Hearing Transcript

Project:	Light Valley Solar
Hearing:	Recording of Issue Specific Hearing 1 (ISH1) - Part 4
Date:	30 July 2026

So now move on to item 4.6, which is the water environment. And just again, I just wanted to check briefly with the applicant that your representatives are at the table. And I will also be coming to the local authority and the Environment Agency for some questions as well on this item.

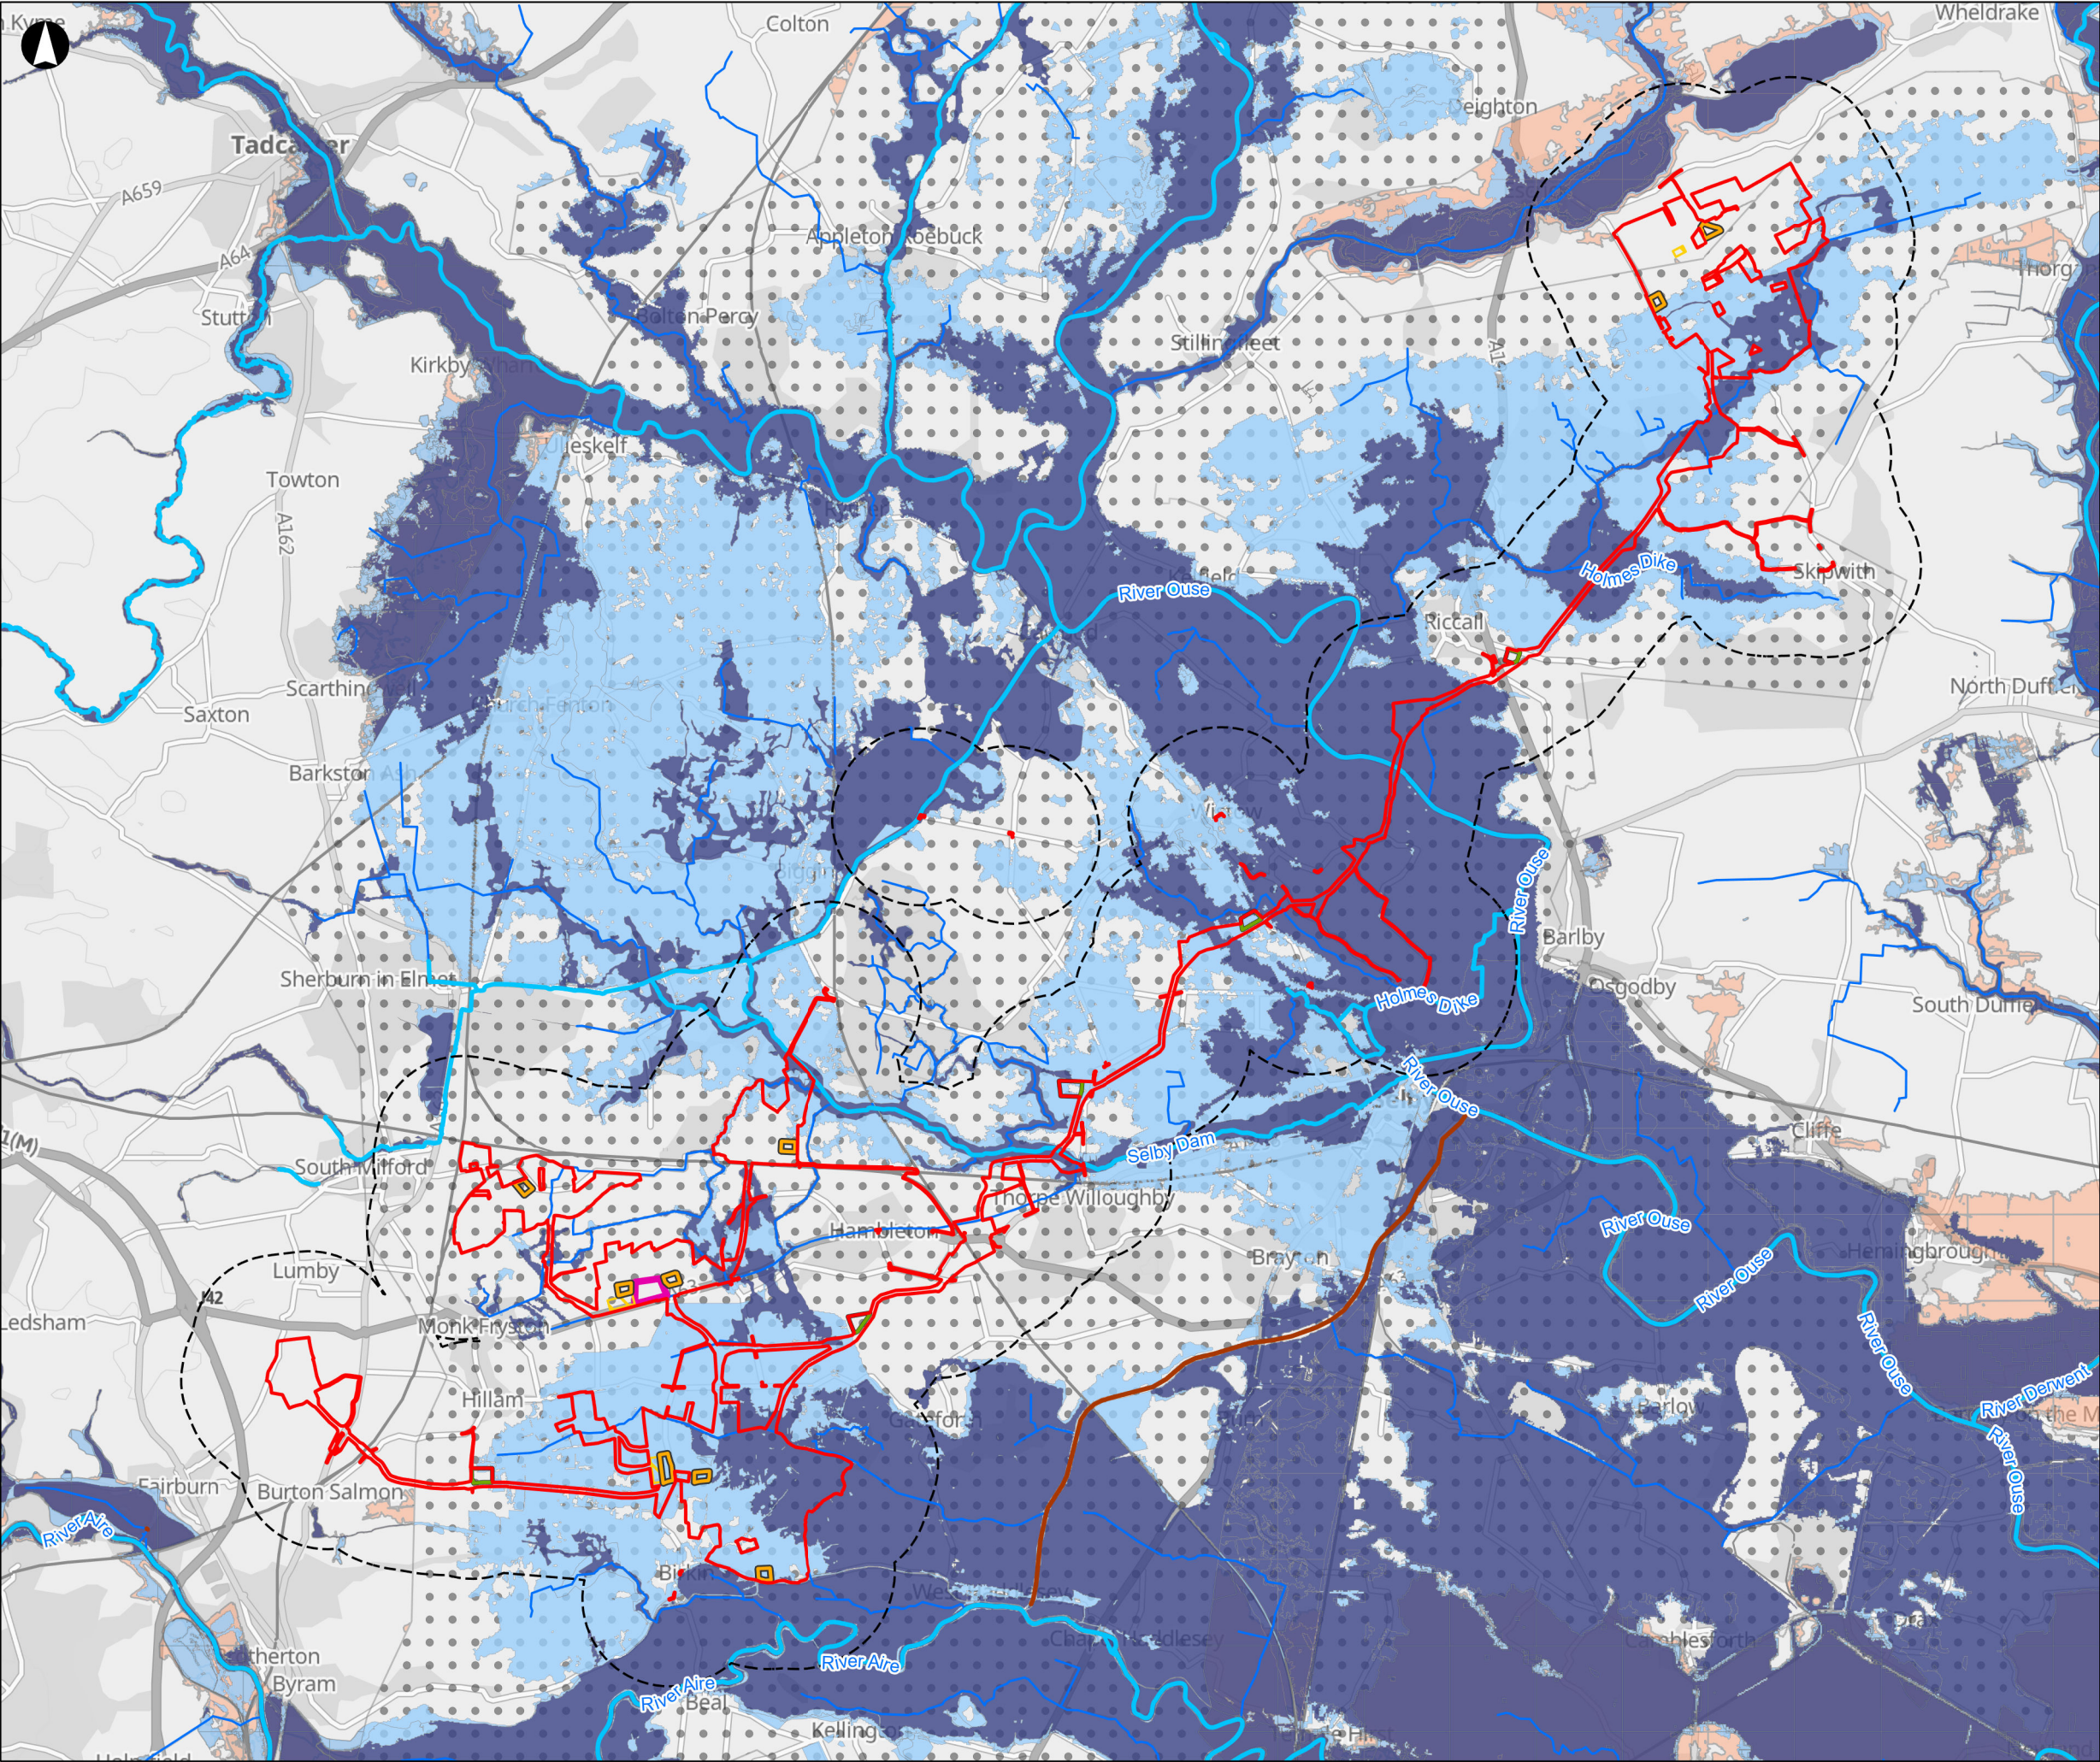
So can I just double check. And I profess to be no expert on this. Um, so. absolute deadline a we submitted, um, a revised figure 15.10 um, which, um, update 011 and that shows flood zone risk zone three on it.

It would be helpful for the applicant to identify the proposed development in relation to flood zone three, be how you want to do that internally and how you want to define that, and what conversations you need to have with the local authority. I will leave that for you to decide, but you need to represent to us proposed developments in relation to Flood Zone CVB and we have asked for this. Hence we do as well that that is an action and we shall carry on. I will just turn to the Environment Agency who's got their hand up and patiently waited.

So currently, in the absence of flood zone 3D mapping and evidence that's been submitted in your statement at procedural deadline, a in the letter, which is PDA 001, you state that there are no areas of flood zone VB within the shell, the development sites of the proposed development, and that the sequential test has been applied during the site selection process. What evidence are you relying upon in the absence of identifying flood zone?

And the applicant. Again I just ask you another question. You just you did refer to environmental statement figure 1510 being updated at deadline A to include the identification of climate change flood zones. This is in exam library reference PDA 011. By adding this data retrospectively. How does this demonstrate that the site selection process considered the future risk of flooding?

Flood sorry. Flood zone three incorporates three A and three B which is the functional floodplain. These plans do not differentiate between the two because we're so far away from three B, and we're not impinging on those areas. It wasn't seen as a priority, but it is relatively straightforward for us to provide that information.

Um, John Holland, on behalf of the Environment Agency, um, this is also a matter that we, um, mentioned in our relevant representation. Um, currently we have received, um, updated documents that I don't think have been submitted into examination currently for review so we can give. Comment on them. At this point in time, the outline for the one and 30 year extent, which, um, we would recommend without stepping on the toes of the local authority because it is obviously their determination for the threads we would recommend to be used as the outline of three B is within the appendix of the model, um report, which then is appendix on to the Fra.

Um, it was obviously a conversation to be had between the applicant and the local, uh, LFA to decide if this is the appropriate extent to use. However, we recommend that a figure of that then be included in the main text of the Fra for that clarity on where that extends it.
